CITY OF ALBUQUERQUE

July 14, 2021

Re: ASI
4500 Paseo Del Norte NE
Traffic Circulation Layout
Architect's Stamp 07-07-2021 (D17-D110)

Sprinkler: Non-Sprinkled

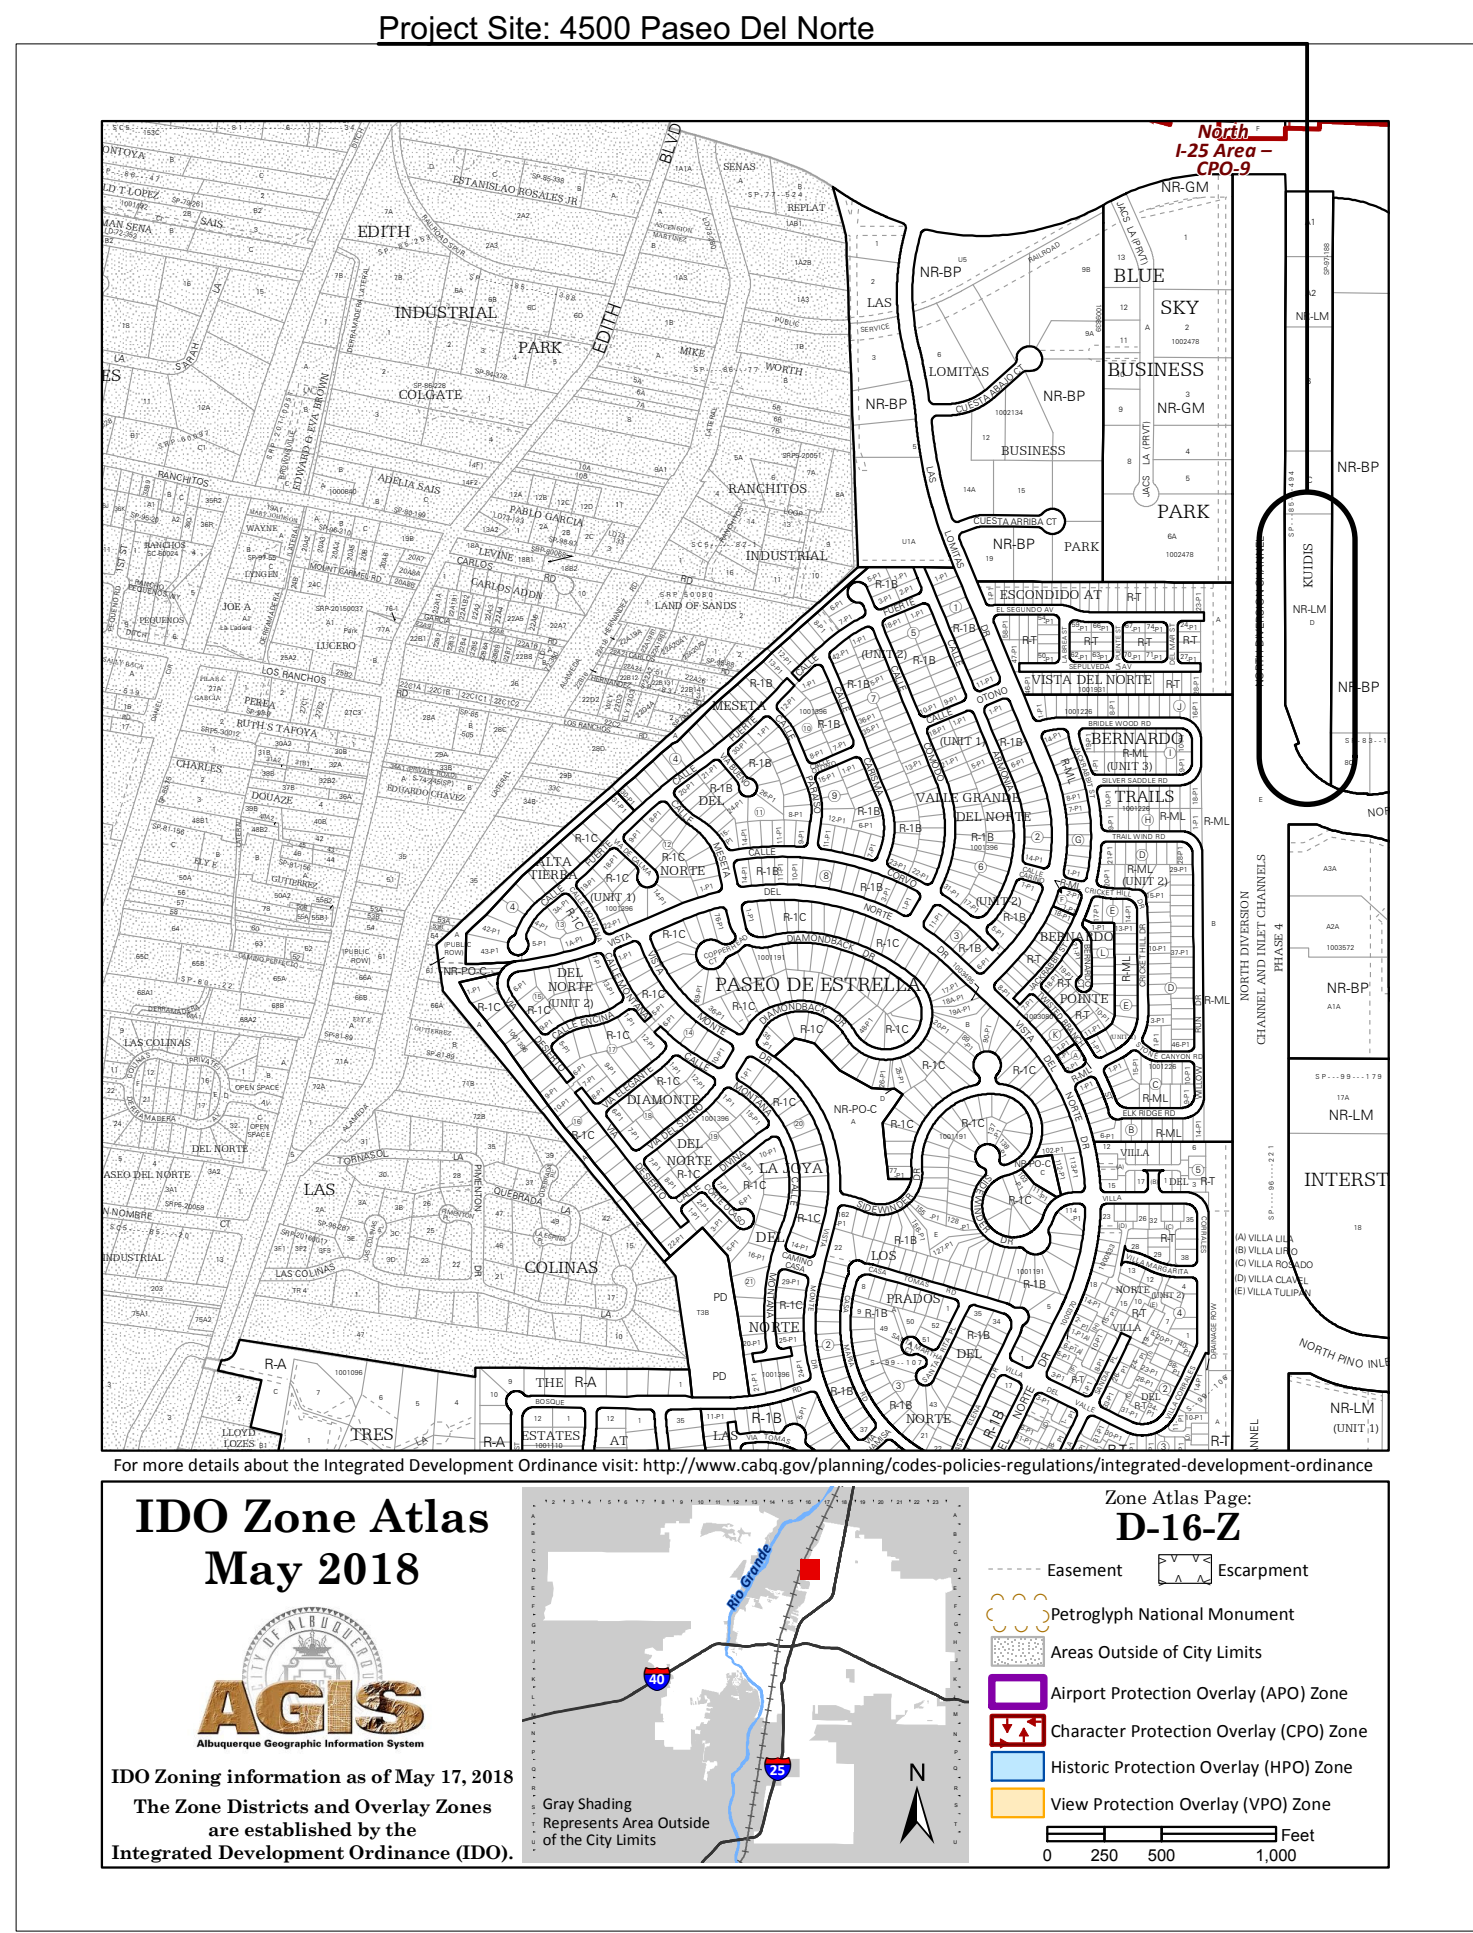
- **Review DPM** for the private **access roadway width** and **sidewalk requirements**.
- Per the IDO, a 6 ft. wide ADA accessible pedestrian pathway is required from the public sidewalk to the building entrances. Please clearly show this pathway and provide details. If applicable and if sidewalk requirements mandate or not.
- All sidewalks along streets should be placed at the property line (if applicable).

2. Per DPM, a 6 ft. wide ADA accessible pedestrian pathway is required from the ADA parking stall access aisles to the building entrances. **Please clearly show this pathway and provide details (Details to include ADA ramp and possibly handrails: also provide dimensions and slopes).**
You need to address this concern and provide details on this subject as stated on prior comments.

3. Detail for parking bumpers/barriers need to be provided.
4. Please provide a letter of response for all comments given.
5. Provide a copy of receipt for the resubmittal fee payment.
